Online Comment

Application H03-0156-19
Location CHAPEL LAS NOMAD MAIN ROAD DEEPING ST NICHOLAS PE11 3HJ
Proposal Erect a shed and fence with garden gate, develop front area to allow for parking

3D View

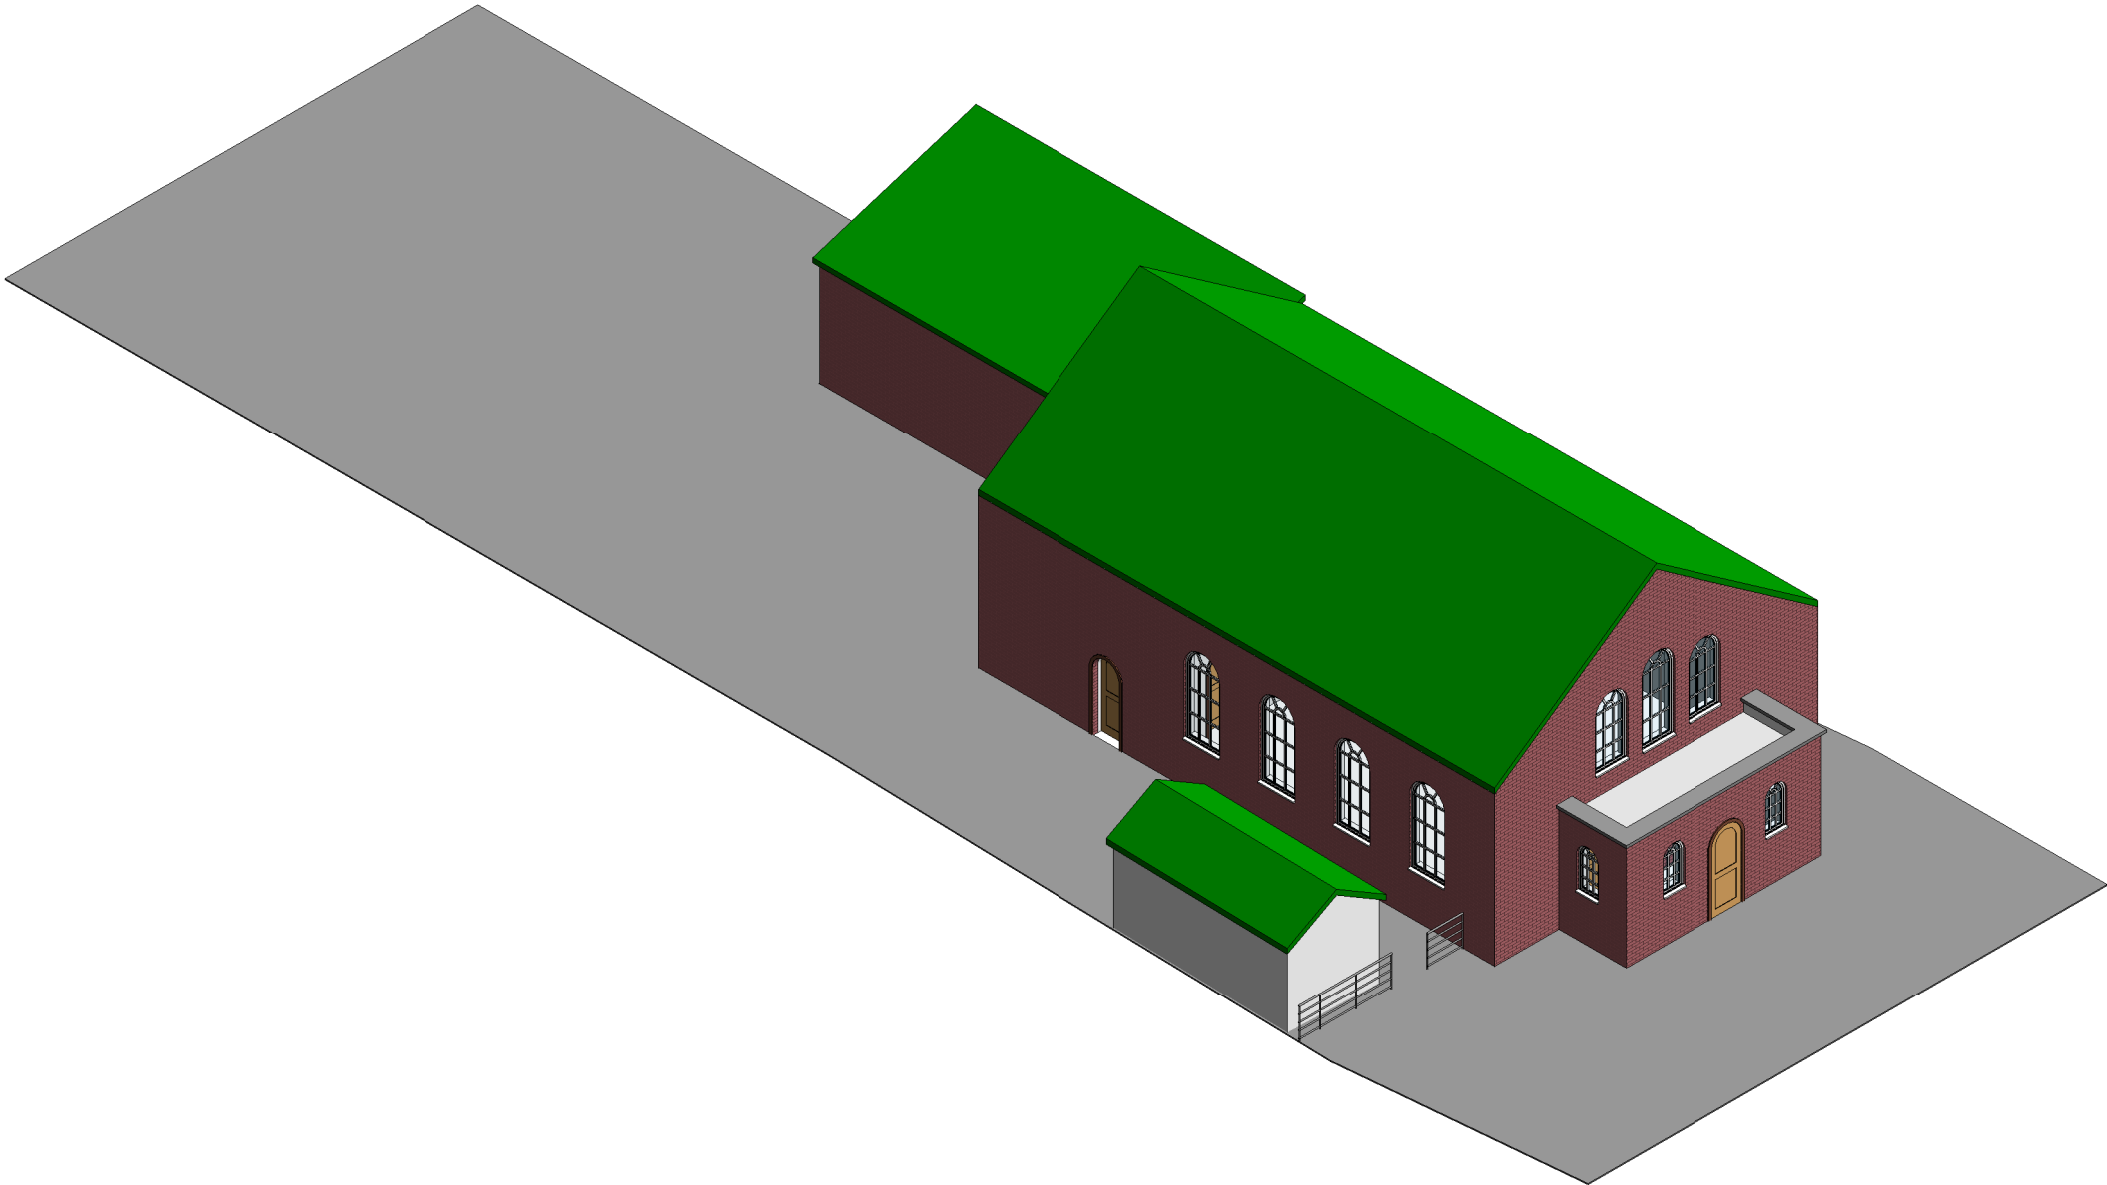
The construction of a shed in this position would harm the setting of this former Methodist chapel, which is recorded in the Lincolnshire Historic Environment Record, and is a non-designated heritage asset as defined in the NPPF.

Positioning the shed in this location would block views of the chapel's side elevation with its distinctive arched windows, and clutter the appearance of the chapel in the street scene domesticating its setting and reducing its prominence. This would be detrimental to the area's character, to which the chapel makes a locally significant contribution. It is recommended that alternative locations be considered that would be less visible.
